Transport
for NSW

Our Reference: SYD19/01450/09
DPIE Reference: SSD-10383

**WESTMEAD CATHOLIC COMMUNITY EDUCATION CAMPUS REDEVELOPMENT
2 DARCY ROAD, WESTMEAD**

Thank you for requesting Transport for NSW (TfNSW) to review a supplementary Response to Submissions (RtS) and amendment report for SSD-10383 'Westmead Catholic Community Education Campus'.

**Figure 2 – Concept design for Darcy Road – Mother Teresa intersection**

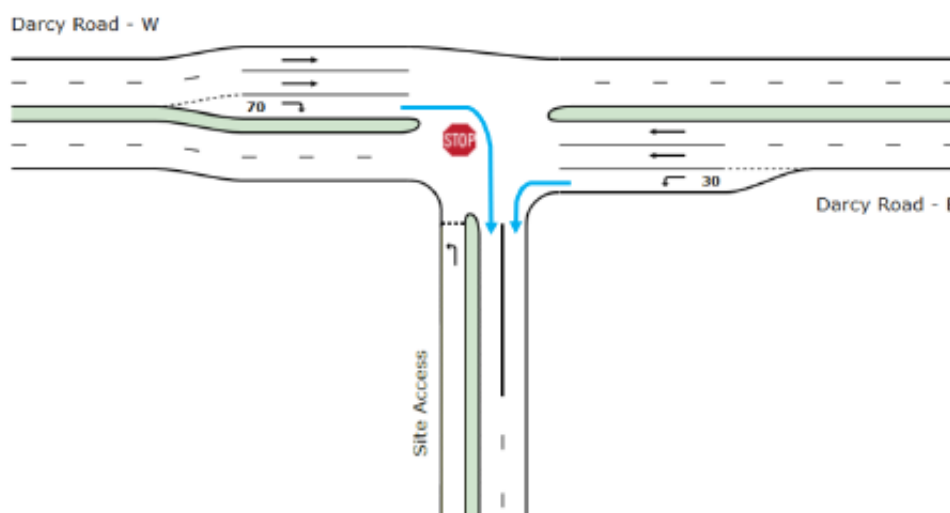
For the opening year 2023 for the proposed development, TfNSW have identified two locations required to be upgraded to ameliorate the traffic generated by the development prior to issuing of a completion certificate.

- The developer shall upgrade the Darcy Road (western side) and Mother Teresa intersection.

The intersection is to operate with a separate left-turn slip lane and right-turn lanes to reduce the walking distance for pedestrians crossing the side road access. The developer will need to obtain section 87 of the *Roads Act 1993* approval and section 138 of the *Roads Act 1993* for the associated works from TfNSW.

**Figure 3 – Concept design for Darcy Road – Catherine McAuley intersection**

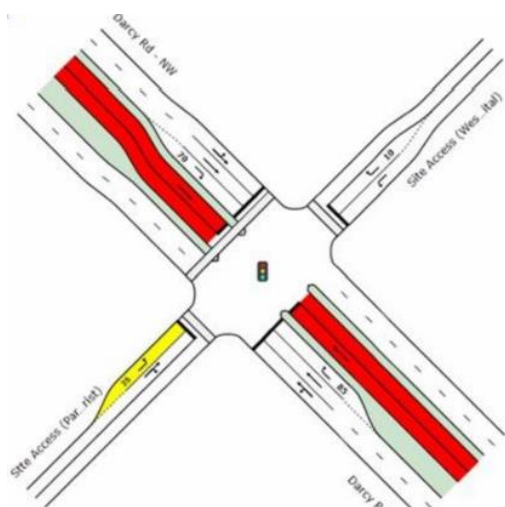
- The developer shall upgrade the Darcy Road (eastern side) / Catherine McAuley Drive / Westmead Hospital intersection.

A dedicated 25 metre left-turn lane on the south approach of the intersection (site exit approach) with an adjacent through and right-turn lane is to be provided. The developer will need to obtain section 87 of the *Roads Act 1993* approval and section 138 of the *Roads Act 1993* concurrence for the associated works from TfNSW.
